Responses by Preston Farms Ltd. and TCS Biosciences Ltd. to points raised in the Examining Authority's written questions dated 2.4.26 (deadline for response 22.4.26)

Preston Farms Ltd.
TCS Biosciences Ltd.

(submitted for them jointly by
Richard Buxton Solicitors, 22.4.26)

TITLE:
FIGURE 3.9A
INDICATIVE CONSTRUCTION AND OPERATIONAL
ACCESS - KEY PLAN

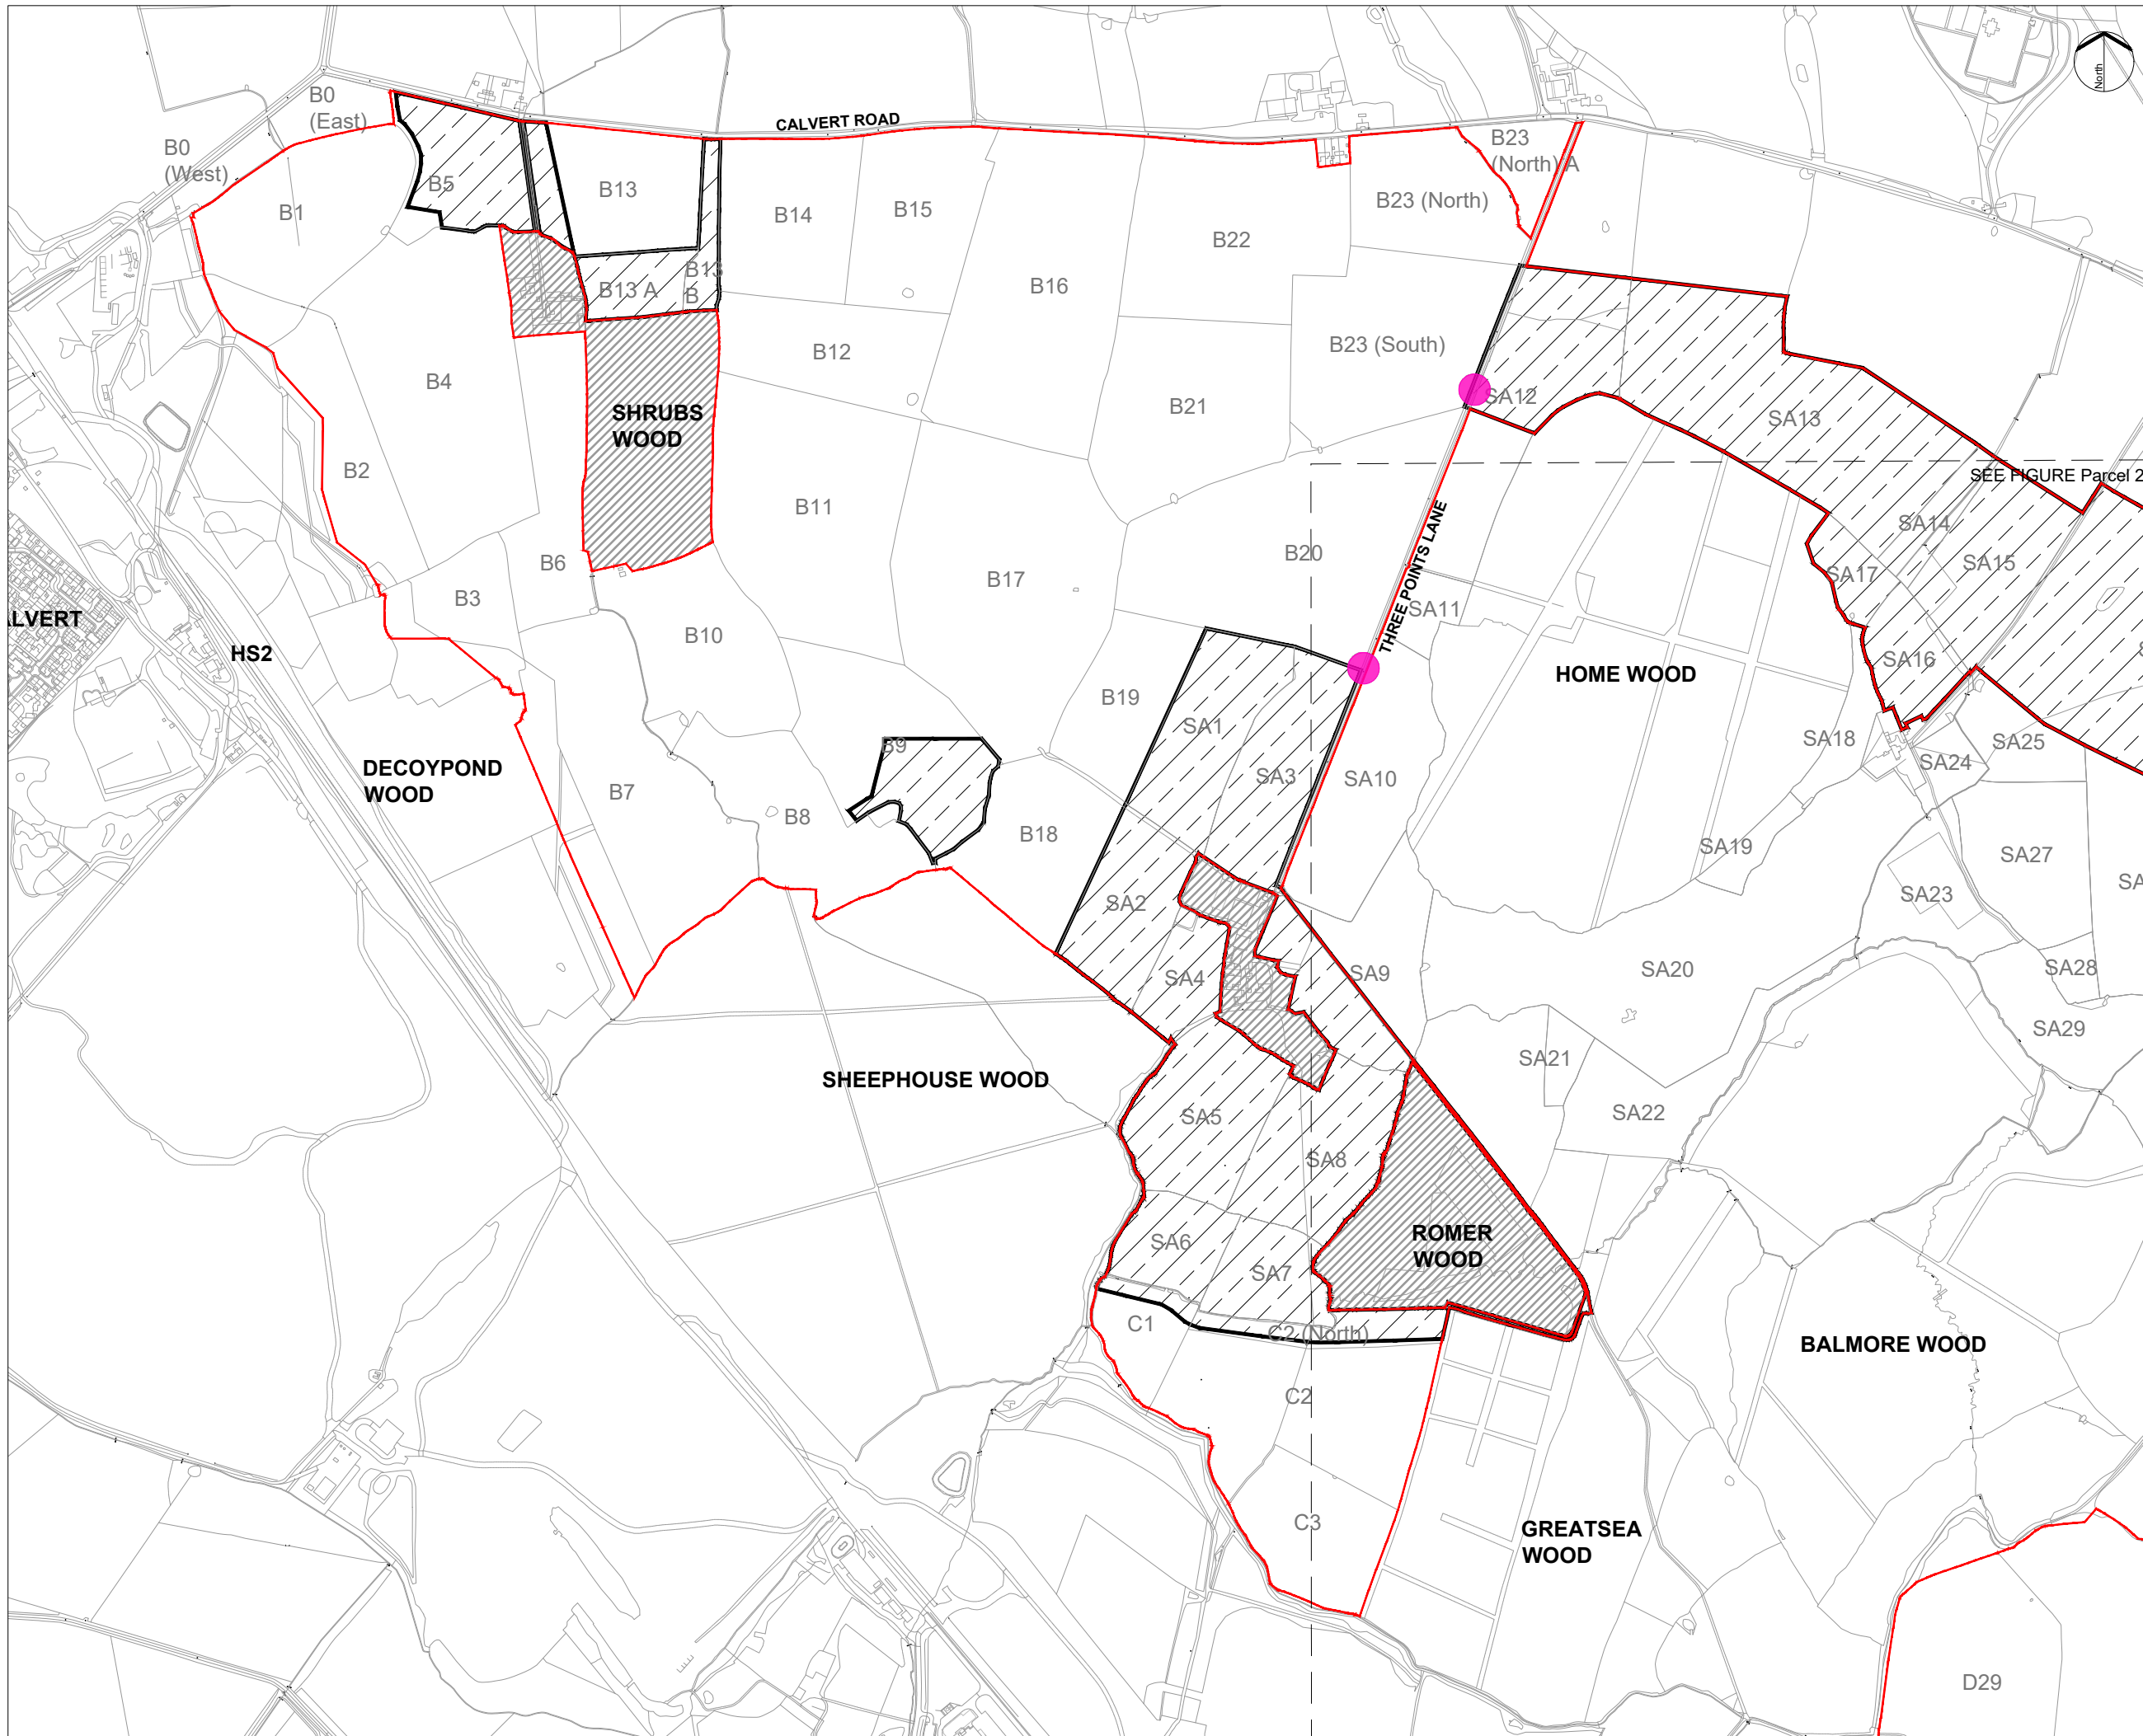
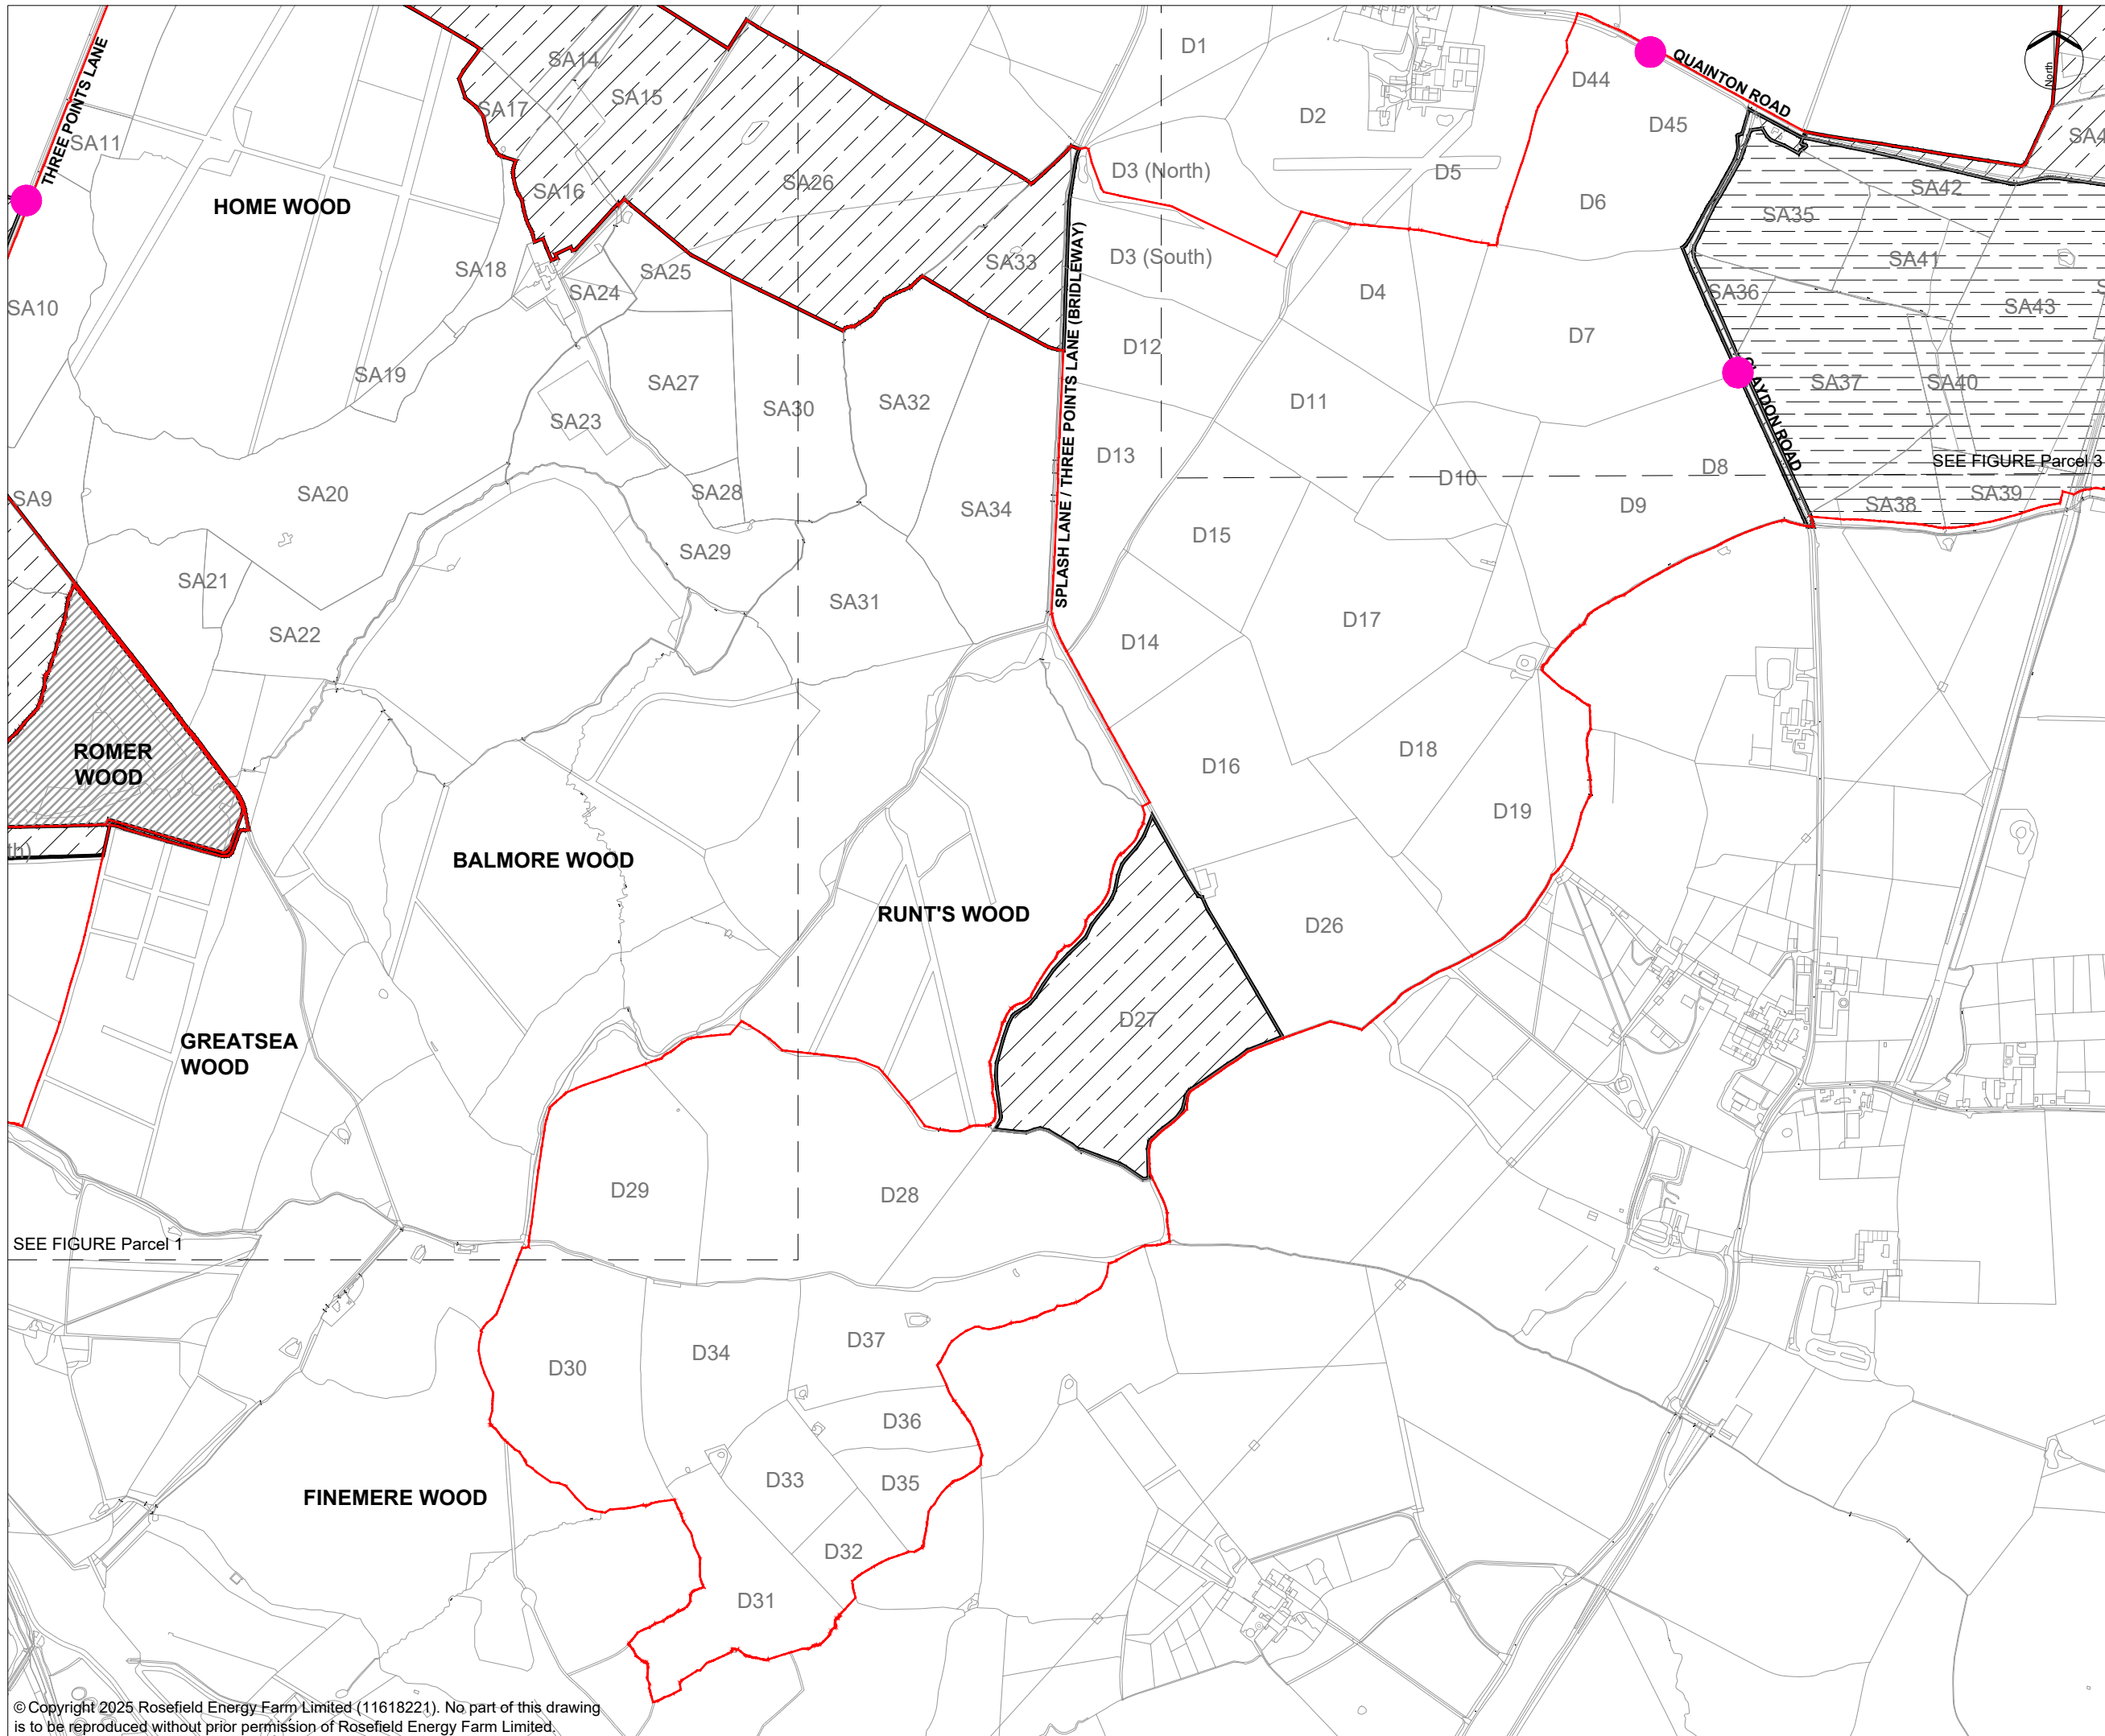
13. PFL and TCS submit that the Applicant's updated Outline Construction Environmental Management Plan [REP1-078], Outline Operational Environmental Management Plan [REP1-080] and Outline Decommissioning Environmental Management Plan [REP1-082] do not adequately address our concerns regarding mitigation measures or monitoring for noise.
14. A central unresolved point is that many of our construction phase noise and disturbance concerns arise because the Applicant continues to proceed based on construction access via Granborough Road, while providing no clear explanation as to why access

from Winslow Road is not feasible (we note it is already being used for abnormal loads). We address this in further detail in response to **Q1.19.13** below.

concerns only to a limited extent. The additions concerning information sharing, liaison with agricultural interests, and the commitment that no construction traffic will travel east on Granborough Road are welcome as far as they go. However, they do not resolve the central problem, namely that the proposed construction route via Granborough Road remains critically problematic for the continued smooth operation of PFL and TCS.

36. As explained in the Written Representation, the proposed construction access route from Granborough Road passes through a key part of the operation and is not compatible with it. This is not a minor inconvenience. Granborough Road provides an important route between different parts of the holding and between the farm and the TCS laboratories in Botolph Claydon. Preston Farms and TCS Biosciences produce donor animal blood 52 weeks of the year which must move quickly around the site (via Granborough Road), and the operation depends upon regular, controlled and uninterrupted movement of staff, livestock, feed and machinery.

39. The amendments to the oCTMP do not answer the prior question of why Granborough Road must be used at all. We have seen or heard nothing from the Applicant as to why access from Winslow Road is not feasible, other than a reference to “commitments” said to prevent that. No clear detail has been provided as to the nature of those commitments or to whom they were given. The Winslow Road is the access option for construction of numerous other infrastructure projects, such as the redevelopment of

the National Grid substation, Stratkraft BESS, Stratera BESS, and Tuckey Solar Farm and so we cannot see any barriers to using that route for the Applicant. The Winslow Road access is just near the north of Parcel 3 where the main Rosefield infrastructure is and it would alleviate many of our concerns about the crossing of our holding except in relation to required cabling. Likewise, no good reason has been given for the need for a permanent maintenance route across the Preston Farms holding after construction. If operational traffic is said to be very limited, that only further raises the question why ongoing access cannot be taken by a less harmful route.
